Subject: VA-20-00007, Fuhrer Setback Variance  
SR 906 MP 1.78 right

We have reviewed the proposed project and have the following comments.

SITE PLAN 1/2" = 6'

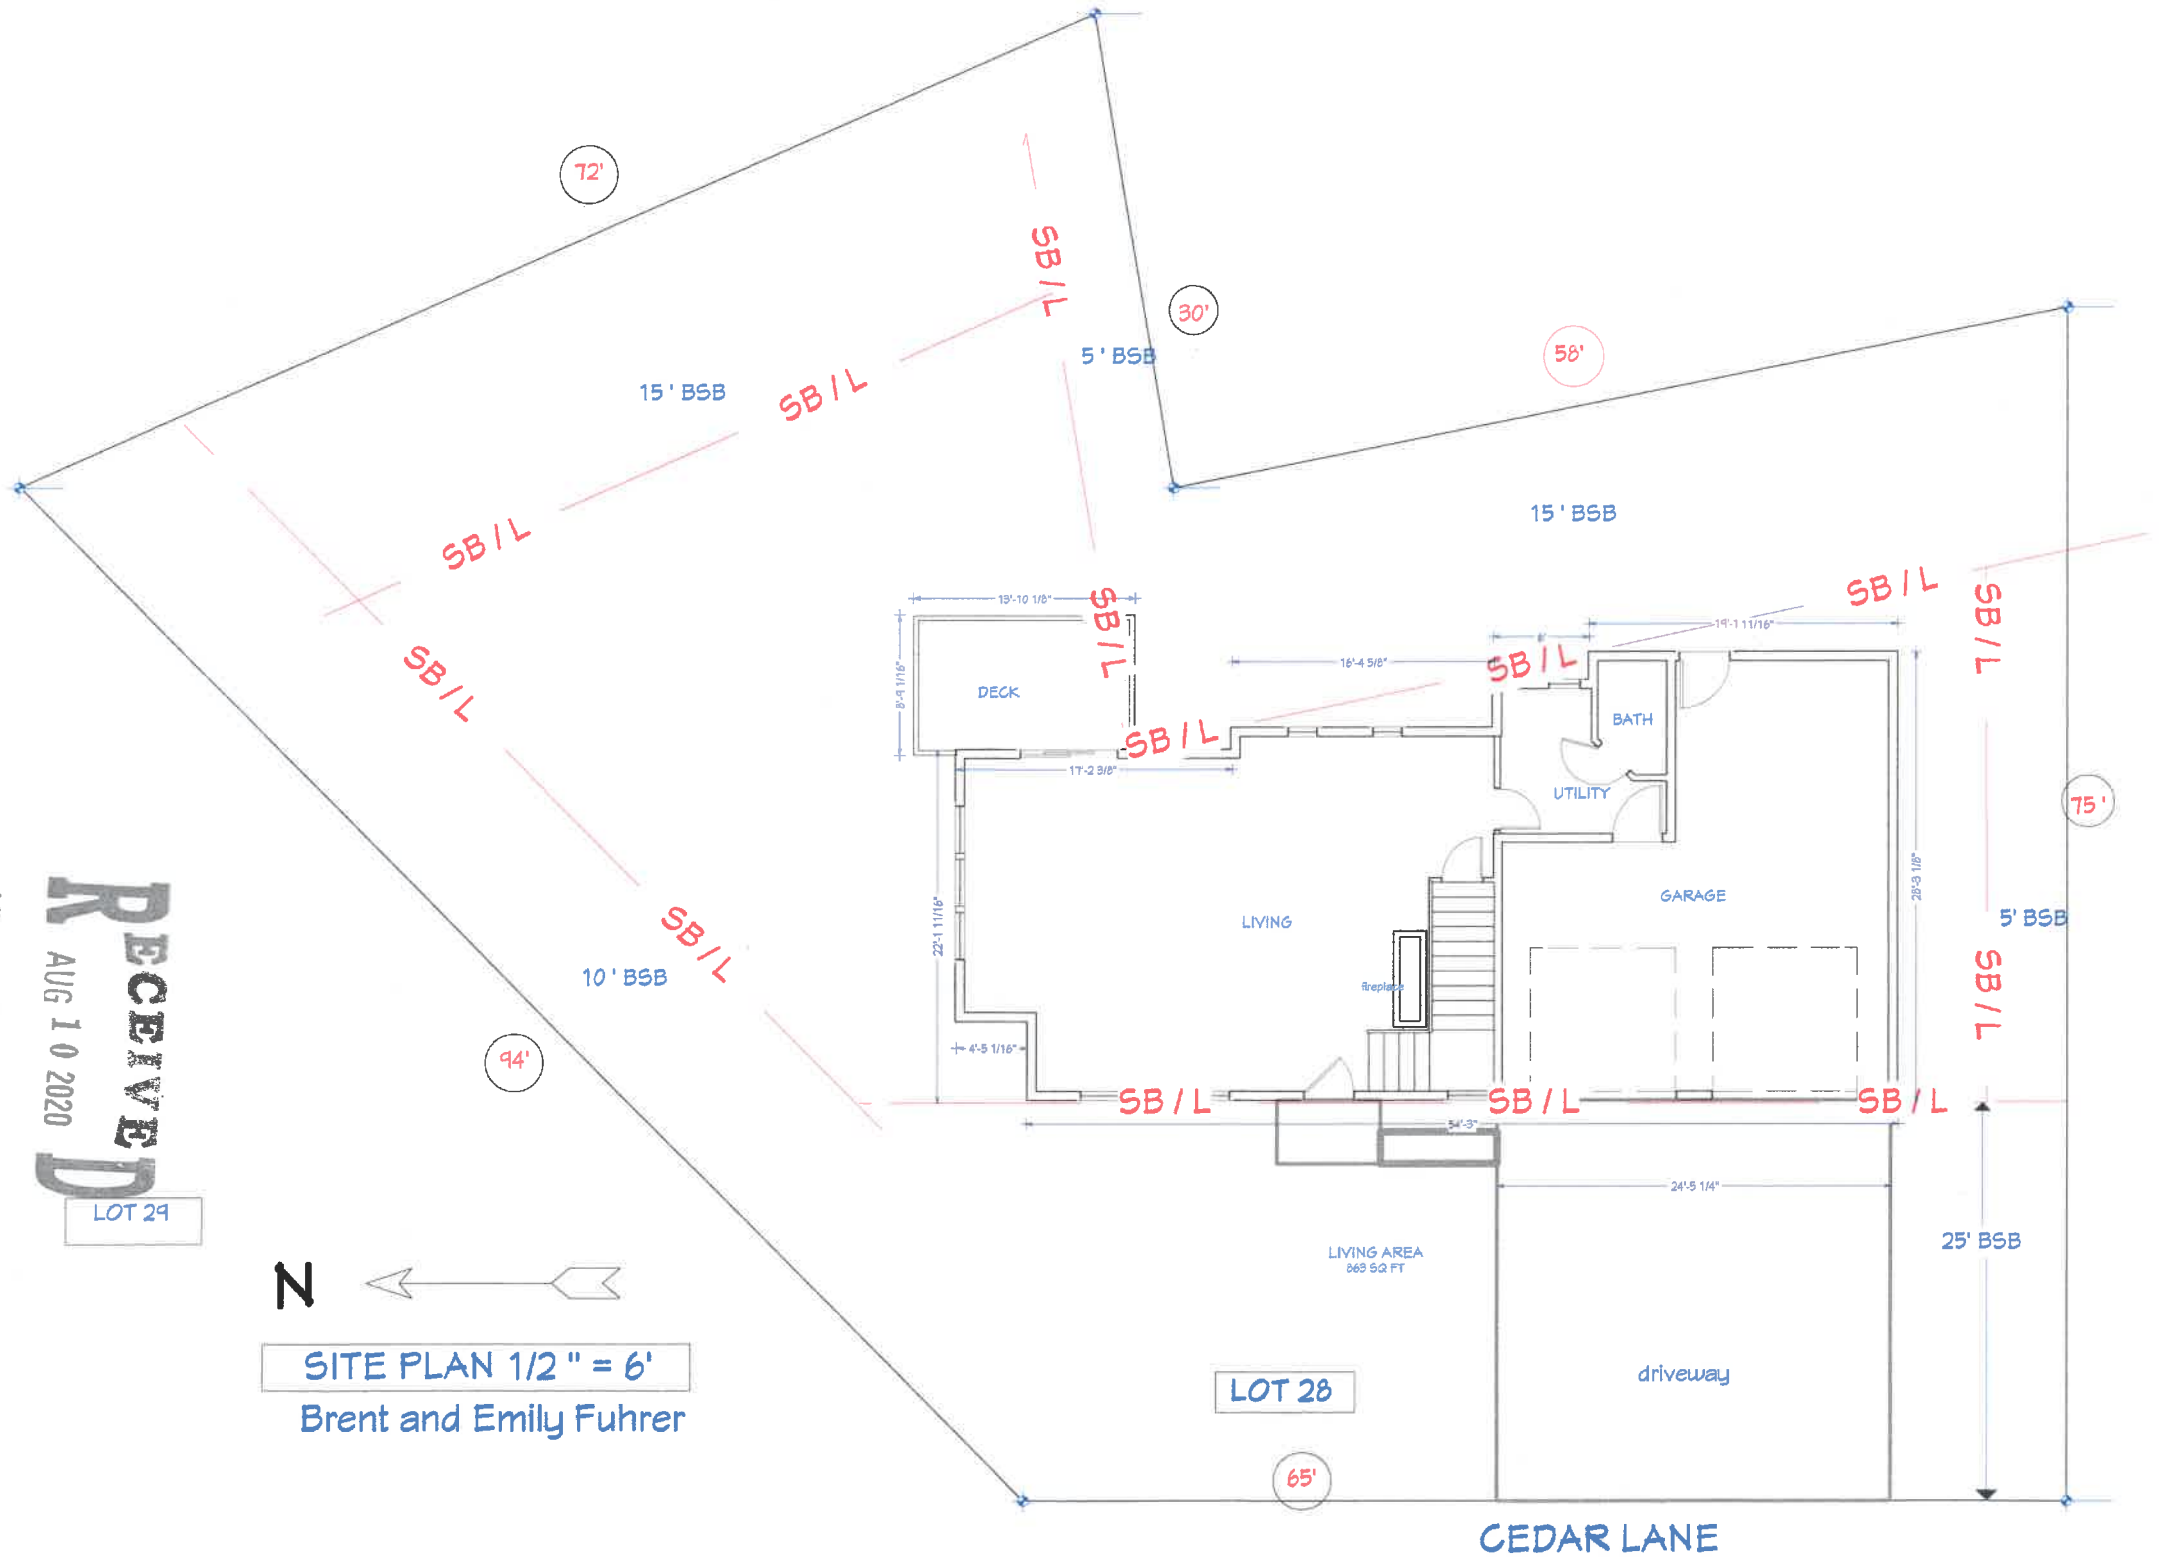
- The subject property is adjacent to the State Route 906 (SR 906). SR 906 is a managed access class 4 highway with a posted speed limit of 35 miles per hour. Direct access to the highway is prohibited.
- The site plan does not identify an area for snow storage. Any snow accumulated on the property shall not be moved onto WSDOT right-of-way. We encourage the proponent to not underestimate the potential for large volumes of snow and designate a snow storage area on the property.
